29 November 2016

Mr Brendon Roberts  
A/ Team Leader – Key Sites Assessment  
NSW Planning and Environment  
GPO Box 39  
SYDNEY NSW 2001

**RESPONSE TO NOTICE OF EXHIBITION – SSD 7745 SITE 18 – NSW RUGBY LEAGUE  
CENTRE OF EXCELLENCE, SYDNEY OLYMPIC PARK**

Sheet Subject
STORMWATER CONCEPT PLAN

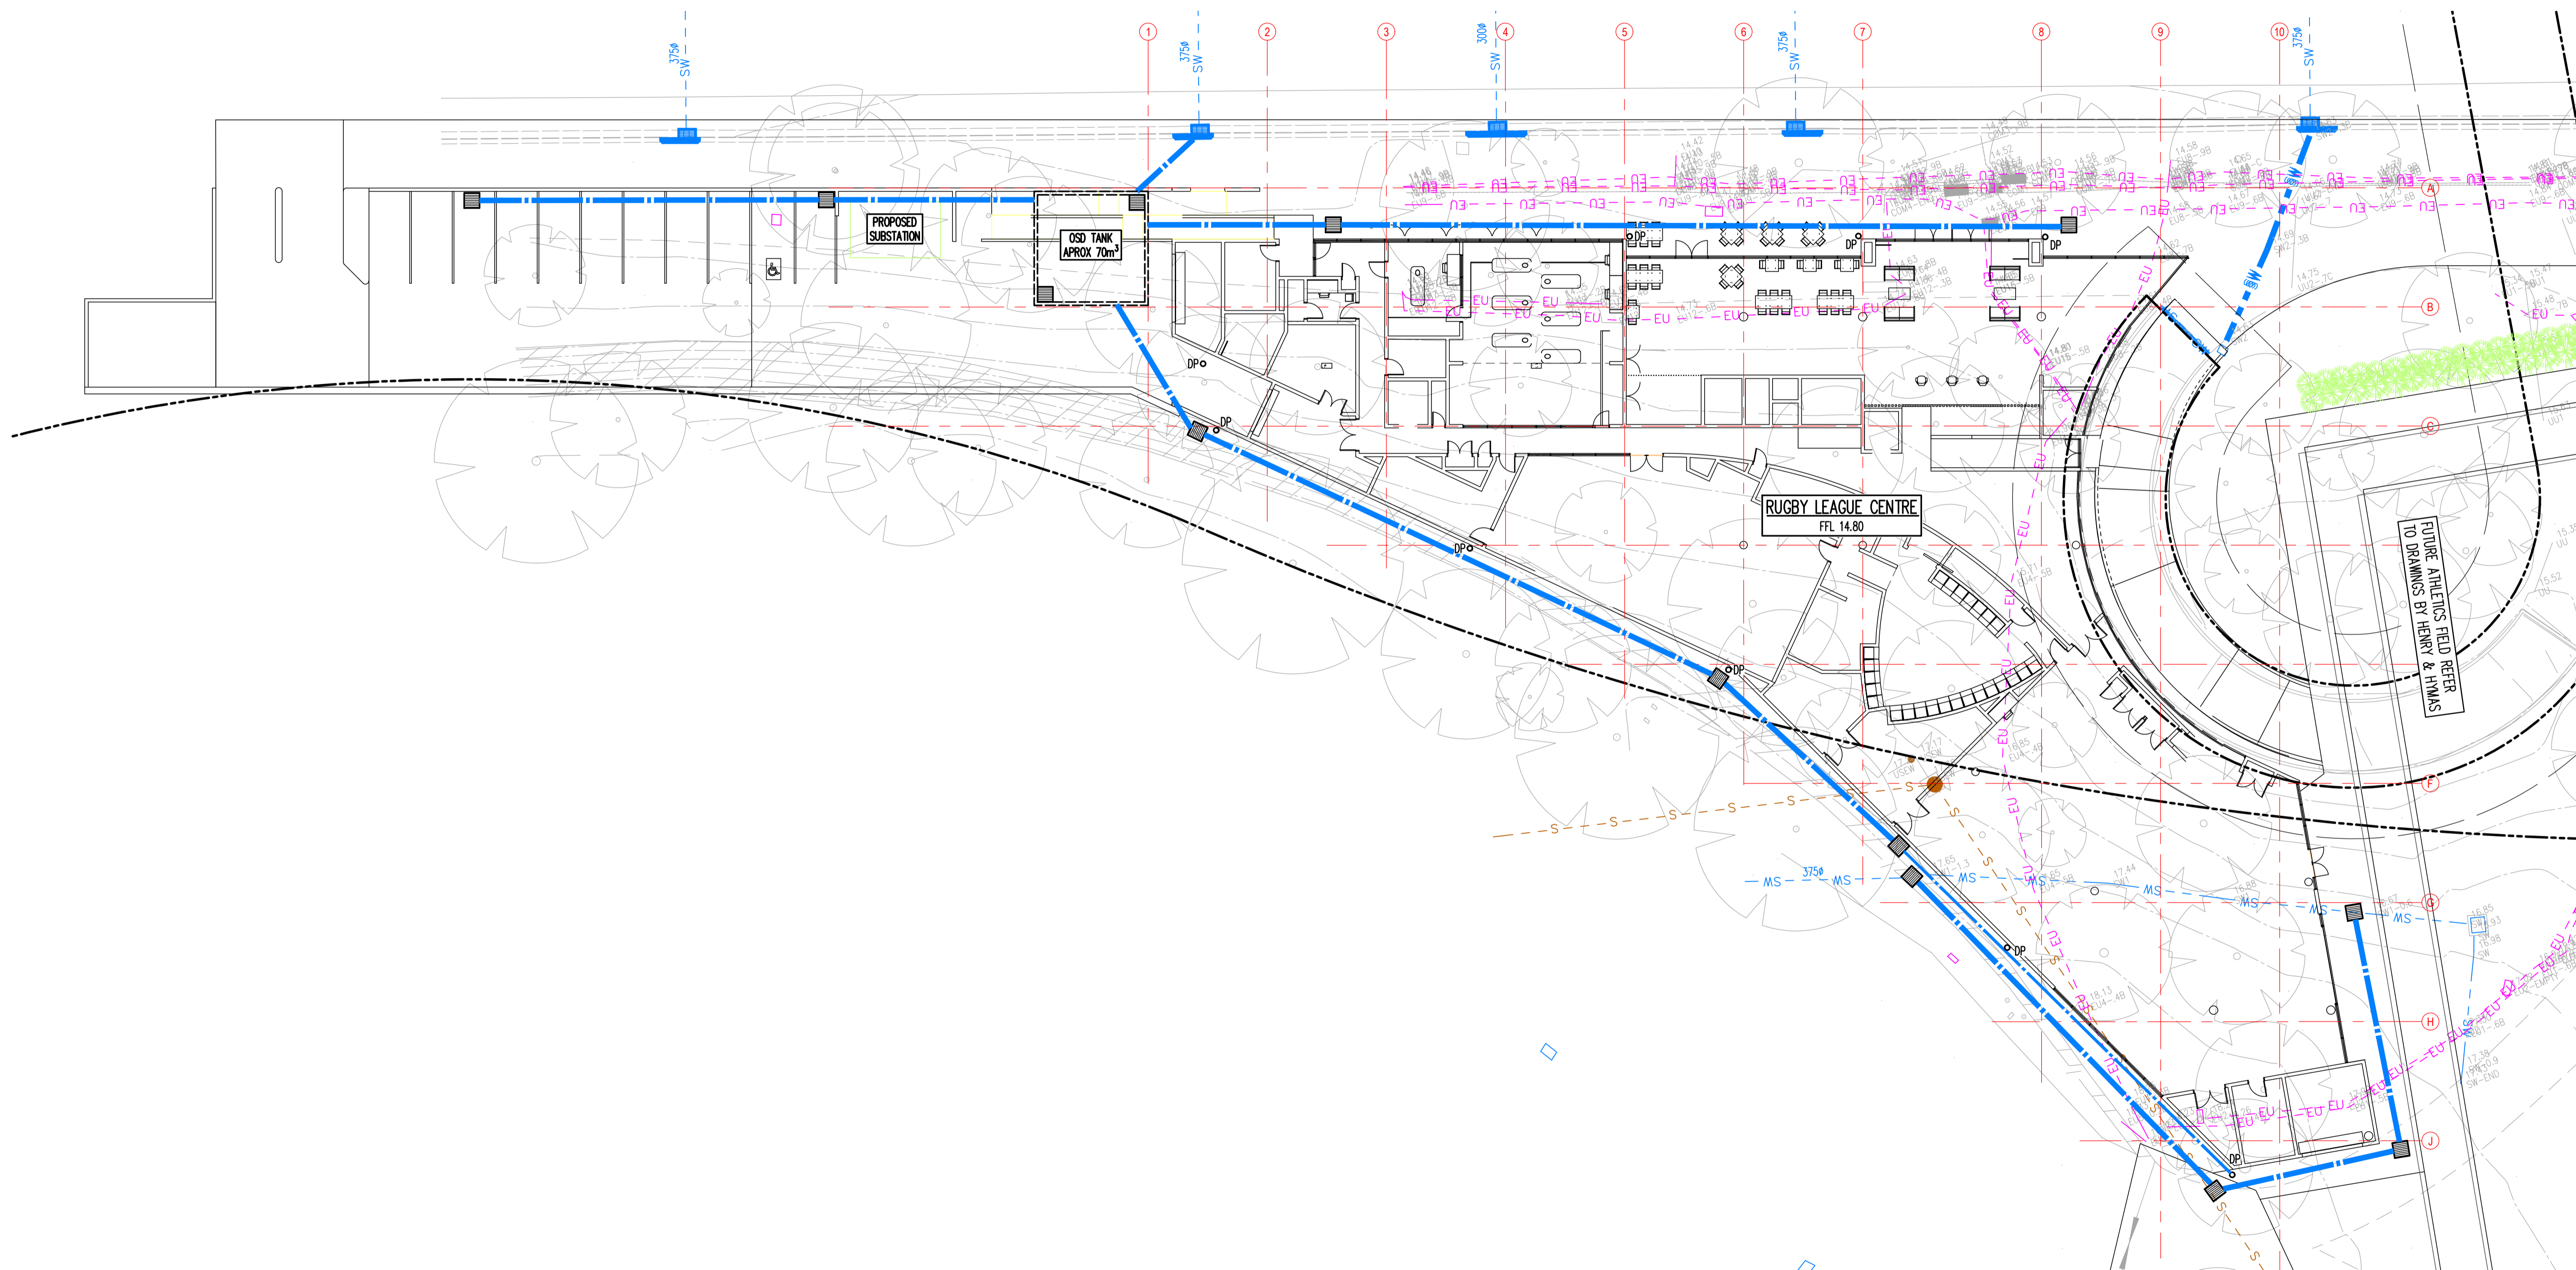
The application does not provide a Soil and Water Management Plan or Integrated Water Cycle Management Plan, prepared in accordance with the SOPA Stormwater Management and Water Sensitive Urban Design Policy. The application does not describe the measures to be implemented to minimise the volume and frequency of stormwater discharge as a result of any impermeable surfaces, such as paving, driveways and car parks, including measures to improve water quality.

Figure 1: Car park layout (Source: Applicant's architectural plans)

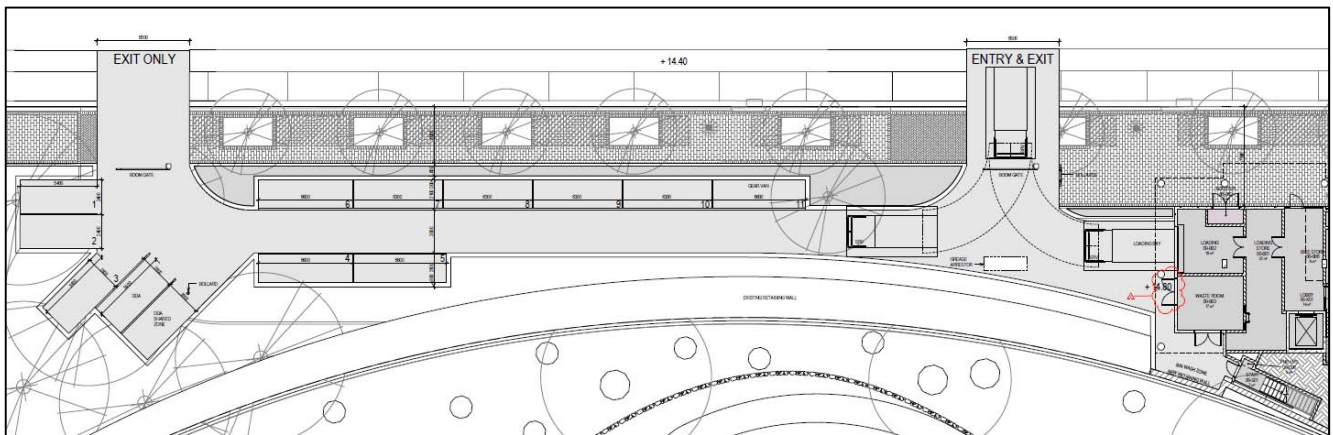
A minimum 4 metre wide footpath should be provided including the front of the proposed car parking area to allow for pedestrian access and the management of people during events. SOPA understands the NSWRL are reviewing the configuration of the car park to provide optimal outcomes.
